**RE: R/143/24/PL - 57 Queensway, Bognor Regis, PO21 1QN**

Following your comments regarding drainage and flood risk, please find our responses below and refer to the two documents that were submitted as part of the planning application:

- FRA[U0560] 57 Queensway , Bognor Regis, PO21 1QW - Flood Risk Assessment
- DS[U0560] 57 Queensway , Bognor Regis, PO21 1QW - Drainage Strategy

# Appendix D

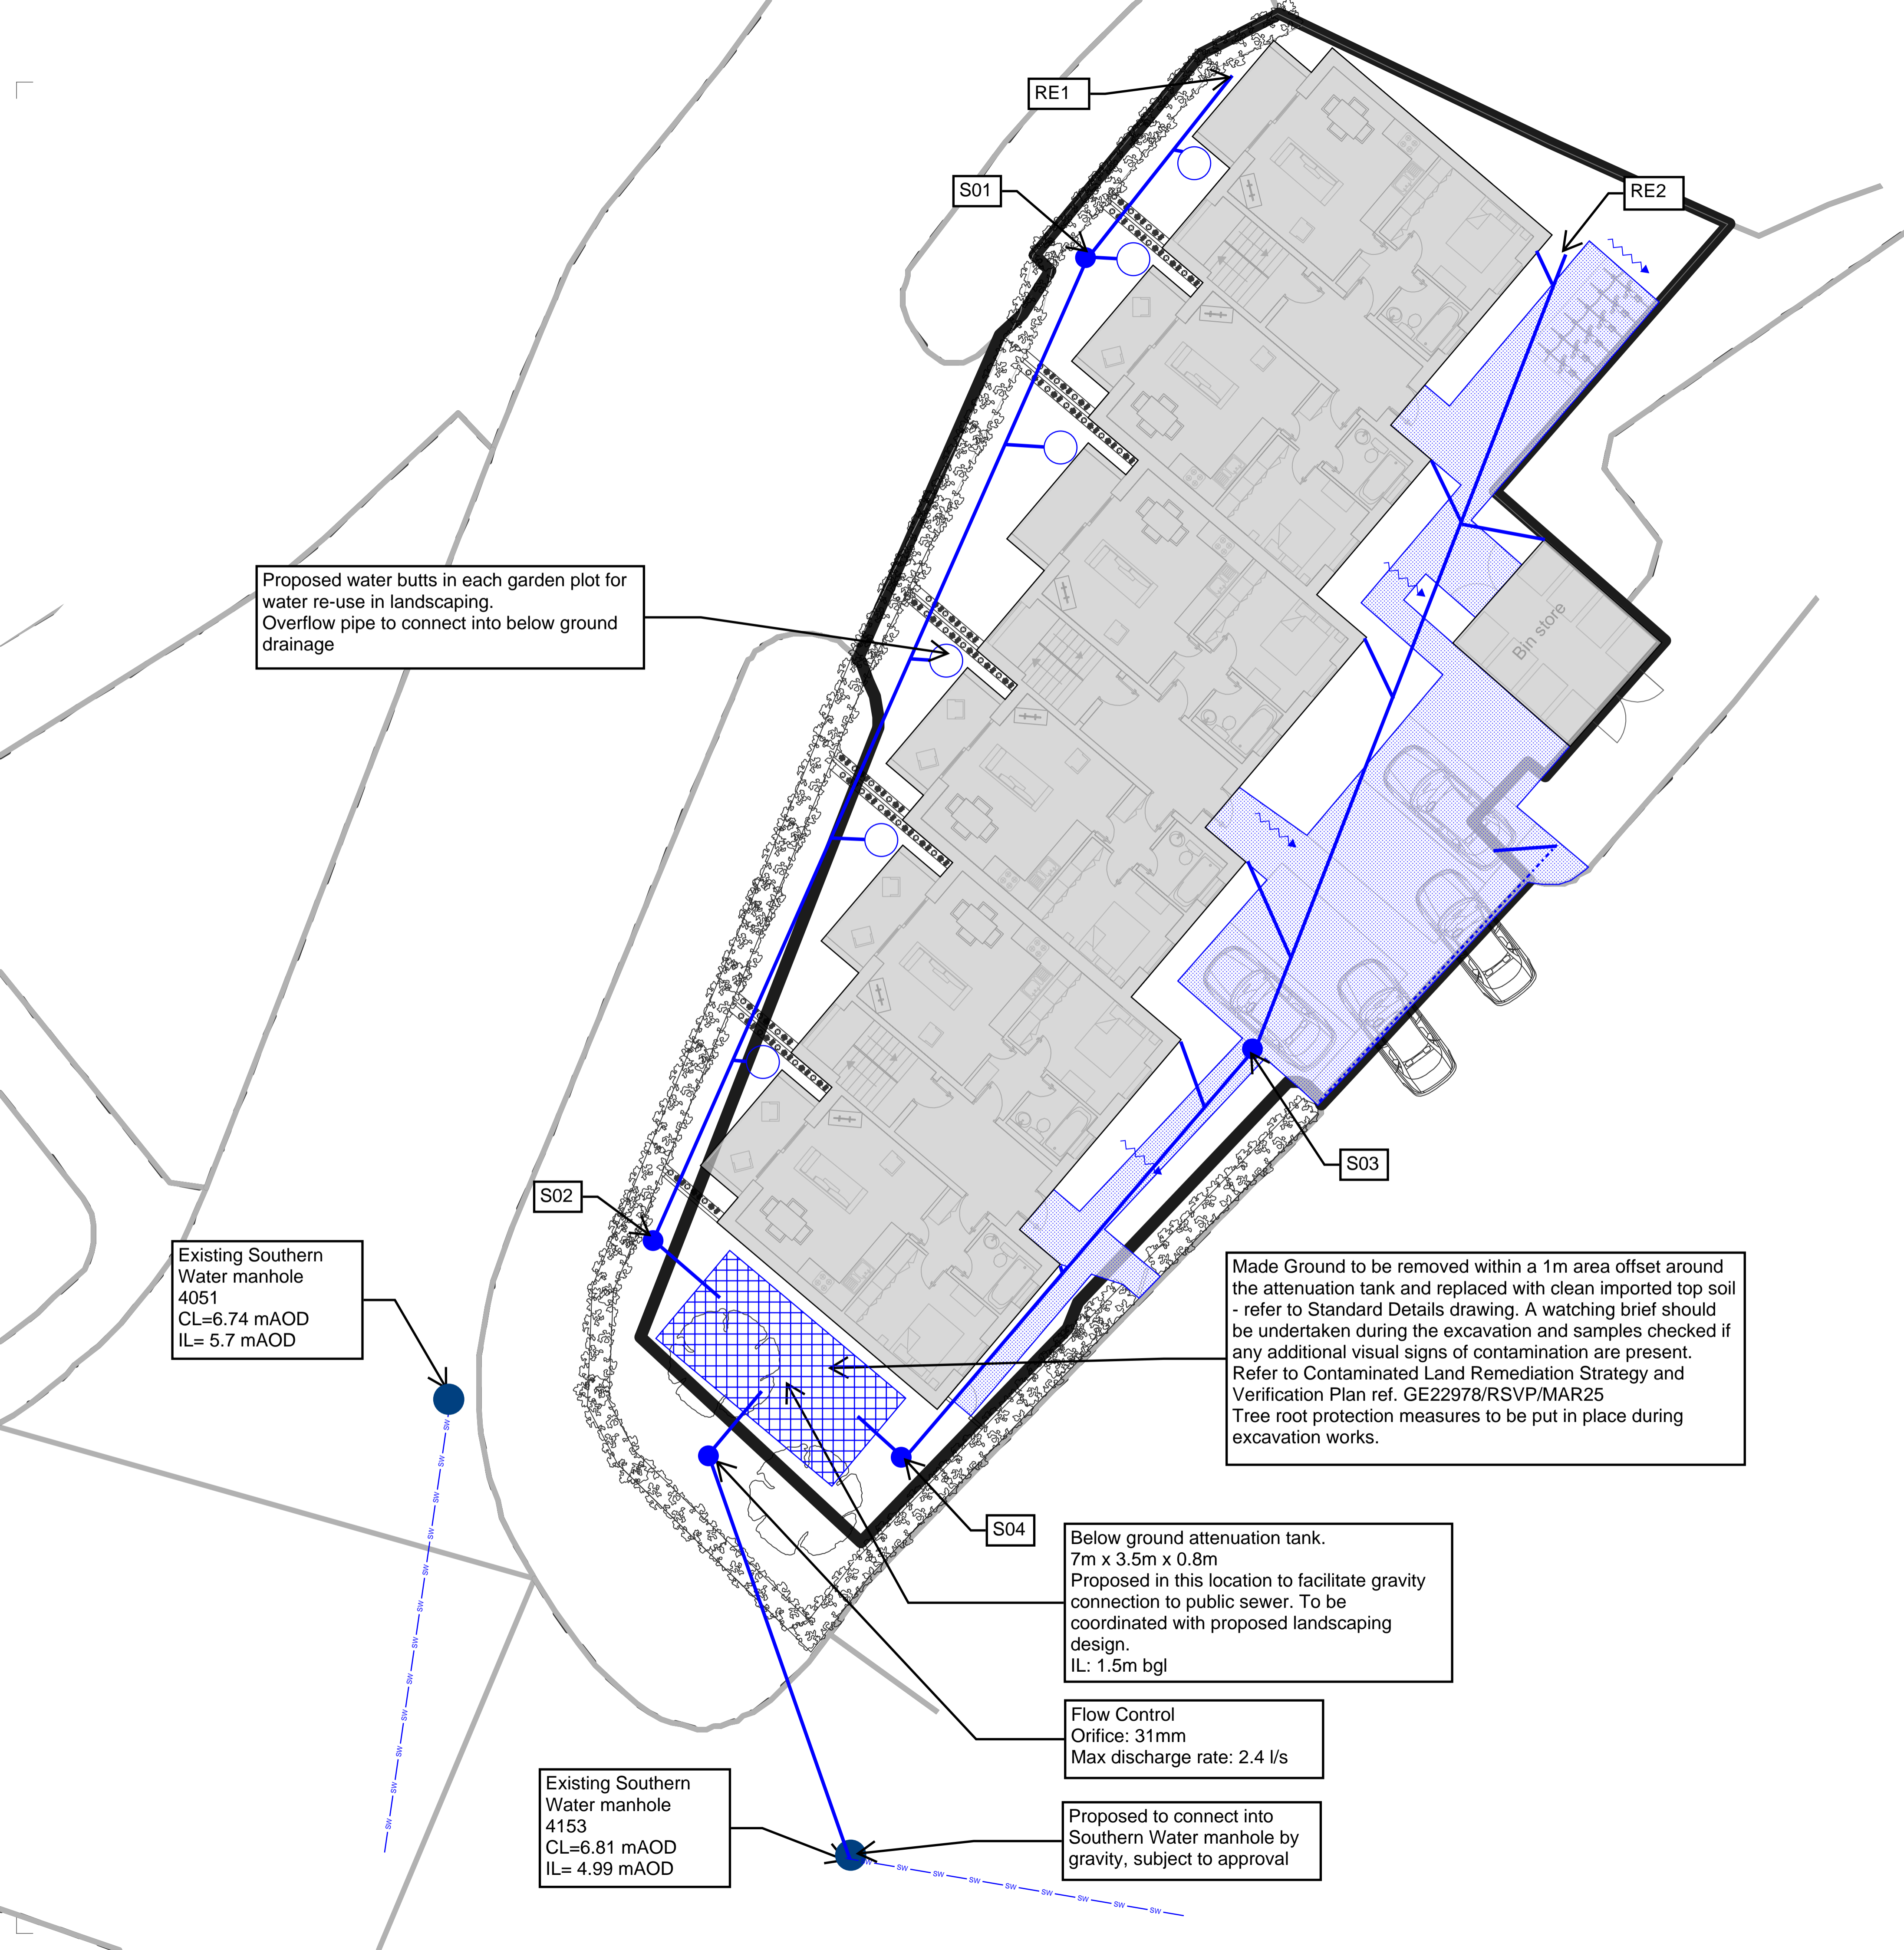
Drawing required to show where existing drainage network and outfall/s are, plus confirmation if will they be retained or removed.	Objection - please provide	All existing site drainage network is to be removed prior to construction. This has been added to the drainage plan in the Drainage Report	Refer to DS[U0560] 57 Queensway , Bognor Regis, PO21 1QW: - Appendix D - p 40 to 41
Drainage survey required to provide evidence of existing discharge rate and condition (may include detailed asset or CCTV survey).	Objection - please provide	A detailed drainage survey (e.g. CCTV) is not considered necessary as all existing drainage infrastructure will be abandoned and removed.  Proposed discharge rates are based on the Modified Rational Method (MRM) for a fully paved brownfield site, with a 60% betterment.  A GPR survey will be undertaken during enabling works to confirm the location of any residual assets. As a new SuDS-based system is proposed, the condition of existing drainage is not relevant to the design.	Refer to DS[U0560] 57 Queensway , Bognor Regis, PO21 1QW: - Appendix D - p 40 to 41

**Permeable Paving - Infiltration**

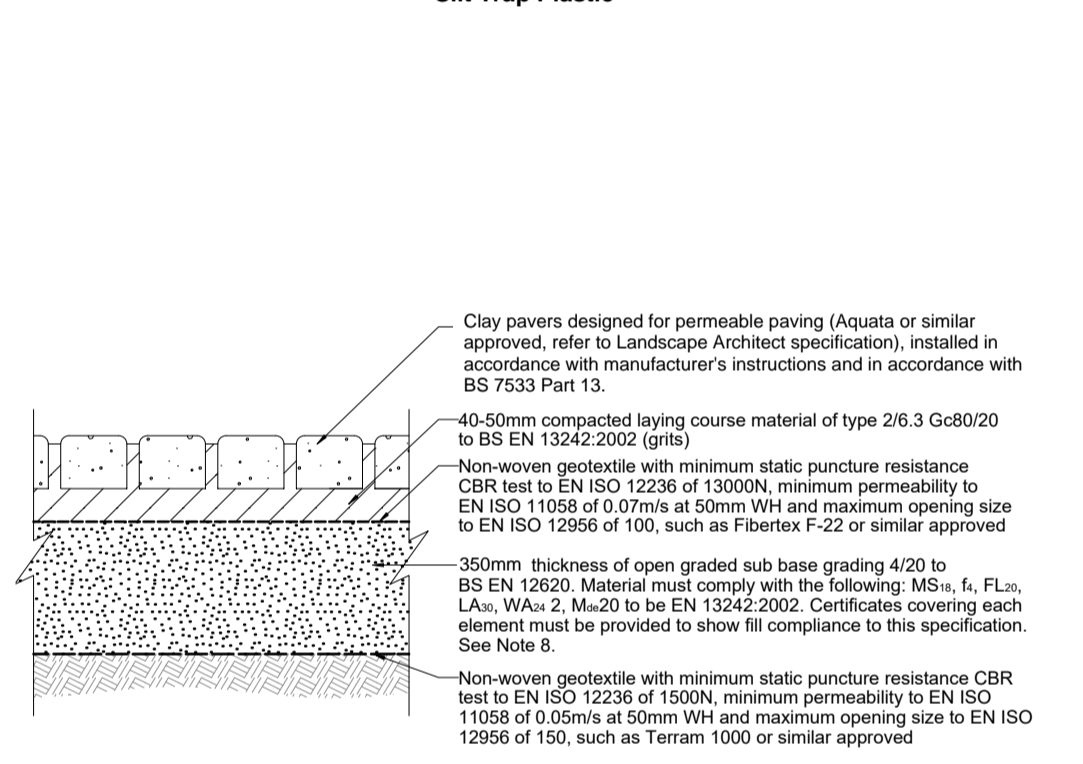
Overarching proposals of how application must provide water quantity benefits in open, at the surface or above ground SuDS.	Objection - no open, at surface or above ground SuDS are proposed	The site constraints do not allow for specific open drainage features. Permeable surfacing is proposed to allow for in-situ shallow infiltration for the hard-paved external areas. Soft landscaping is provided on the southern edge of the development, and within each dwelling plot as garden amenities.	Refer to DS[U0560] 57 Queensway , Bognor Regis, PO21 1QW: - Appendix D - p 40 to 41
Commitment to the use of SuDS and high-level assessment to include: <input type="checkbox"/> water quality <input checked="" type="checkbox"/> biodiversity <input checked="" type="checkbox"/> amenity	Objection: Please provide information on biodiversity and amenity.	The site constraints do not allow for specific open drainage features. Permeable surfacing is proposed to allow for in-situ shallow infiltration for the hard-paved external areas. Soft landscaping is provided on the southern edge of the development, and within each dwelling plot as garden amenities.	Refer to DS[U0560] 57 Queensway , Bognor Regis, PO21 1QW: - Appendix D - p 40 to 41

**Cellular Attenuation System - Landscape Area**

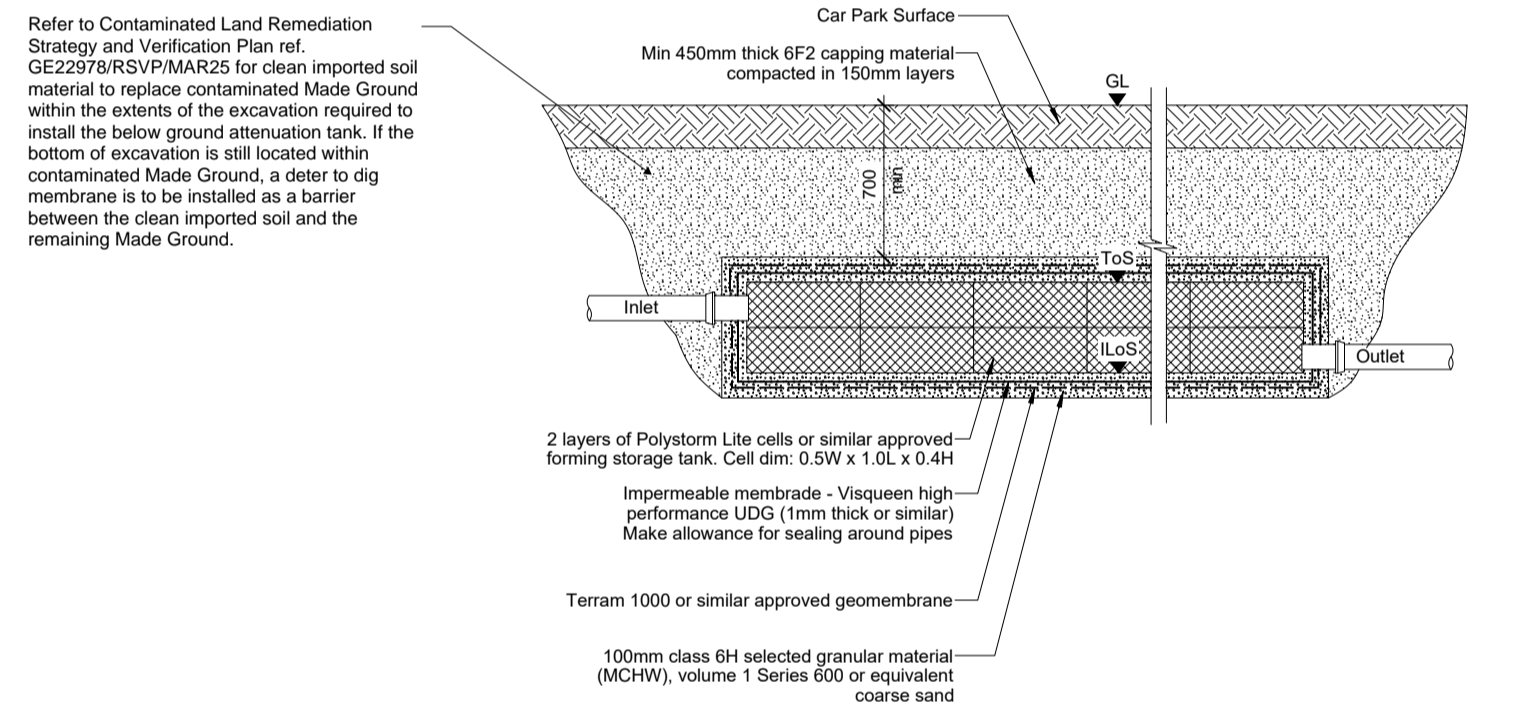
The most precautionary infiltration rate should be used in the design of the attenuation feature.	Objection: Infiltration testing has not been undertaken	Given the spatial constraints of the site, a soakaway is not considered feasible as it would not meet the 5m minimum clearance from a building. Therefore a soakaway solution is not proposed, requiring no infiltration testing. The attenuation is proposed in the form of a below ground geocellular storage tank.	Refer to DS[U0560] 57 Queensway , Bognor Regis, PO21 1QW: - Appendix D - p 40 to 41

**Rainwater Butt**

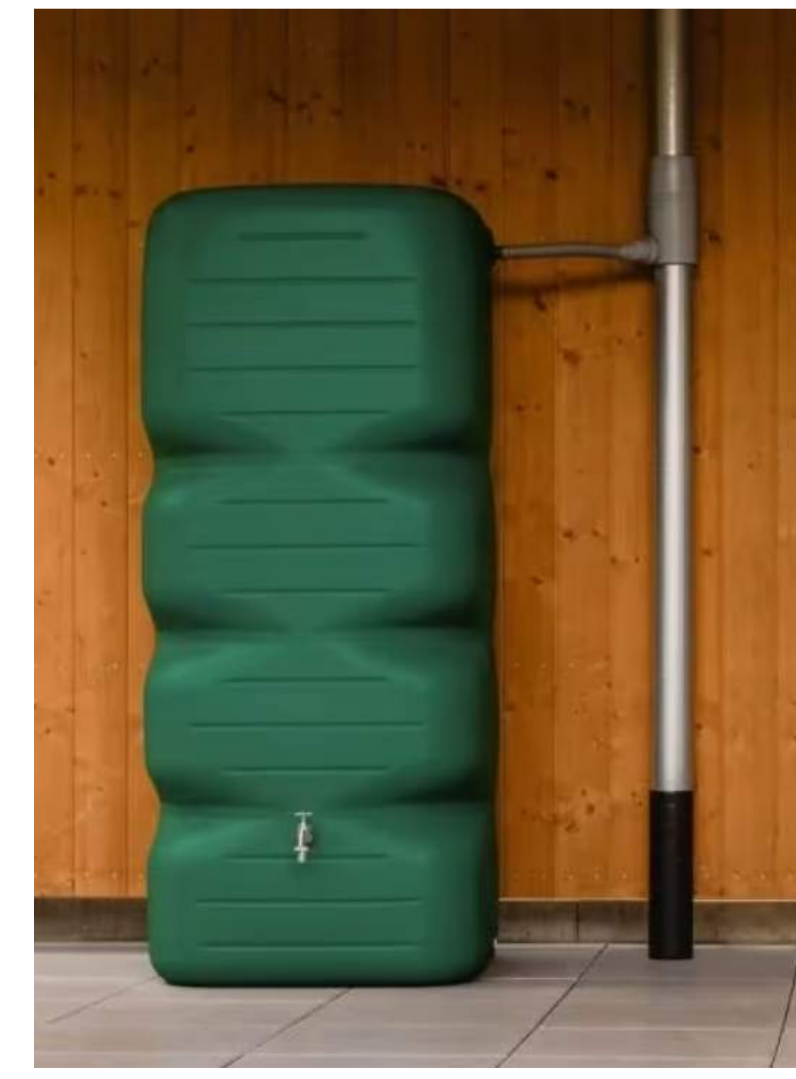
Drainage location hierarchy has not been followed, further information is required on; evidence why rainwater reuse can't be included	Objection: The LLFA require the applicant to submit information on why rainwater cannot be reused.	Water butts have been added to the development to provide reuse for the external landscaping.	Refer to DS[U0560] 57 Queensway , Bognor Regis, PO21 1QW: - Appendix D - p 40 to 41
Interception has not been calculated and /or provided	Objection: The LLFA require the applicant to submit information on interception.	The drainage proposals include: - Permeable paving for external hardstanding, allowing the first 5 mm of rainfall to infiltrate and evaporate on-site, and - Water butts connected to roof drainage, providing rainwater harvesting for landscape irrigation.	Refer to DS[U0560] 57 Queensway , Bognor Regis, PO21 1QW: - Appendix D - p 40 to 41
